Date: 23rd August 2017

RE: Proposed Erection of 59 dwellings and associated means of access App. Ref. 2017/91623; and

Outline application for residential development and convenience store, and provision of open space APP. Ref. 2016/91967. At Land at Dunford Road, Hade Edge, Holmfirth.

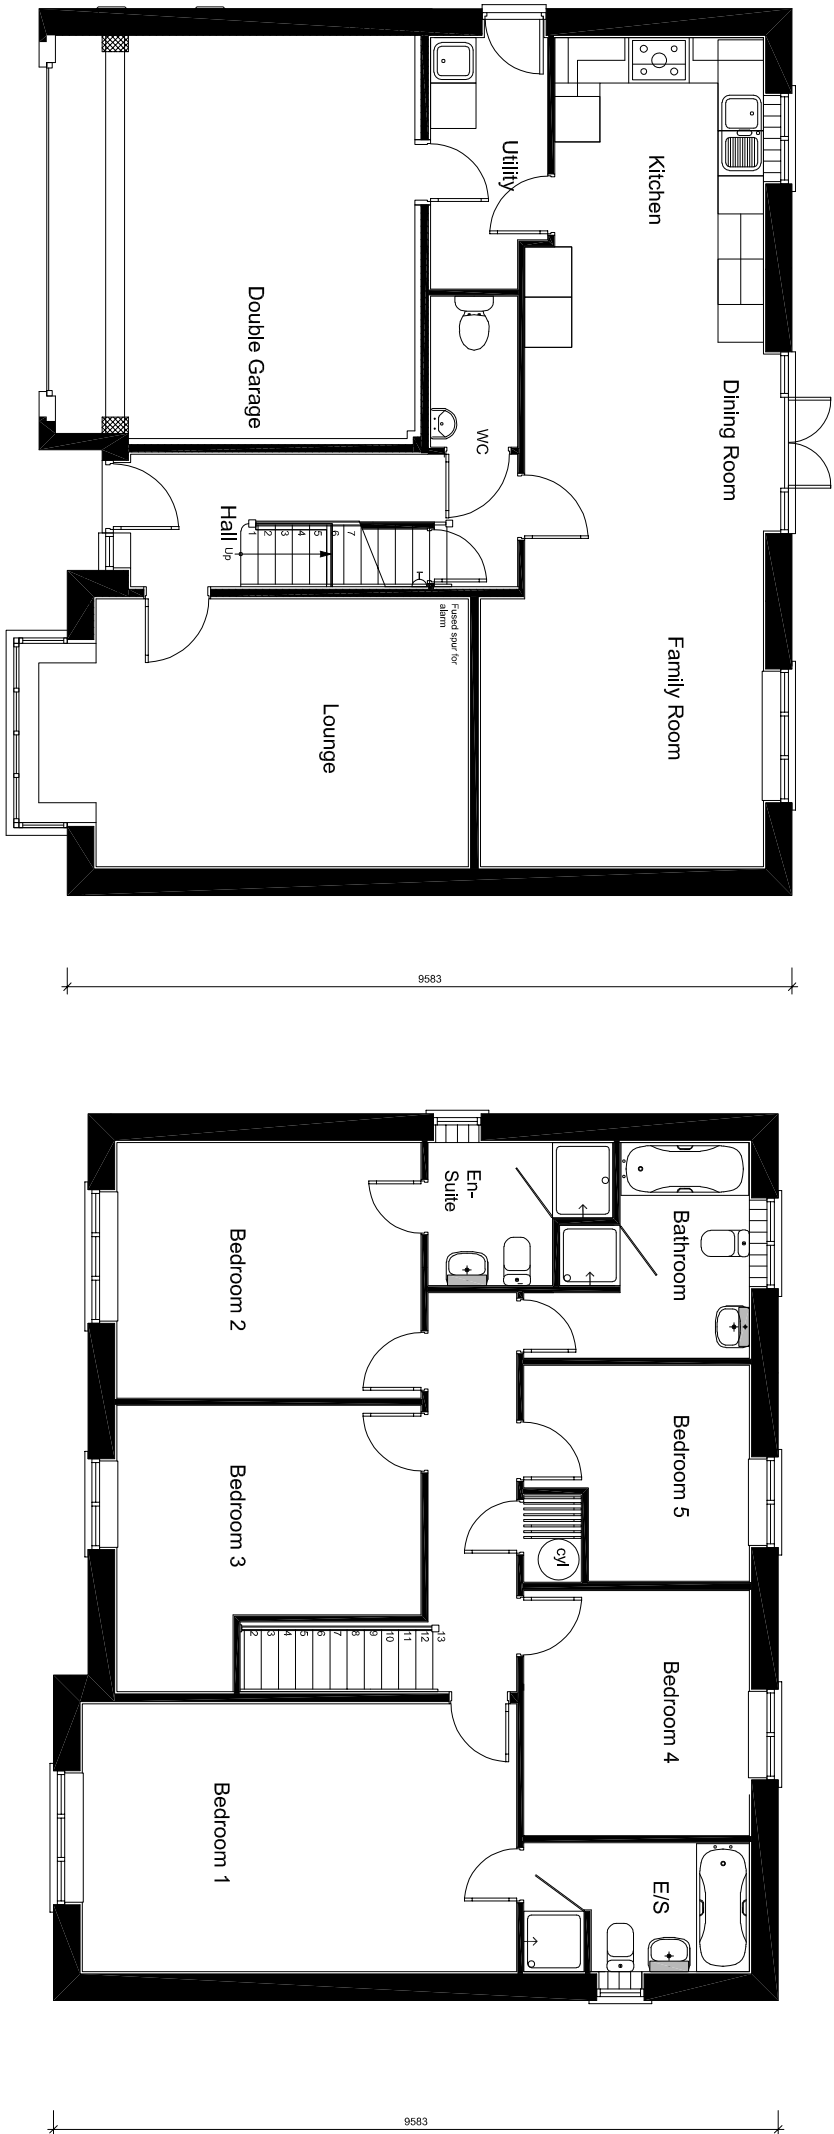
The scale and layout of the proposal would significantly fill this space and add a heavier urban quality that would be conspicuous in the scenery and landscape character flowing from the National Park. The location of the site, proposed suburban housing designs, layout and use artificial building materials would fail to re-inforce local distinctiveness by introducing a further development of a suburban character. As such it would be incongruous and have an adverse effect on the setting of the National Park and therefore the character and enjoyment of the National Park itself.

- Revision of density and layout of development to provide urban rather than suburban character reflecting the landscape character type and historic field pattern.
- Revision of the form of proposed buildings to reflect the local vernacular and avoid suburban design. Use of traditional natural gritstone and slate for walls and roofs.
- Introduction of landscape buffer along the southern edge of the scheme.
- Use of gritstone walling to front boundaries to create vernacular streetscape.
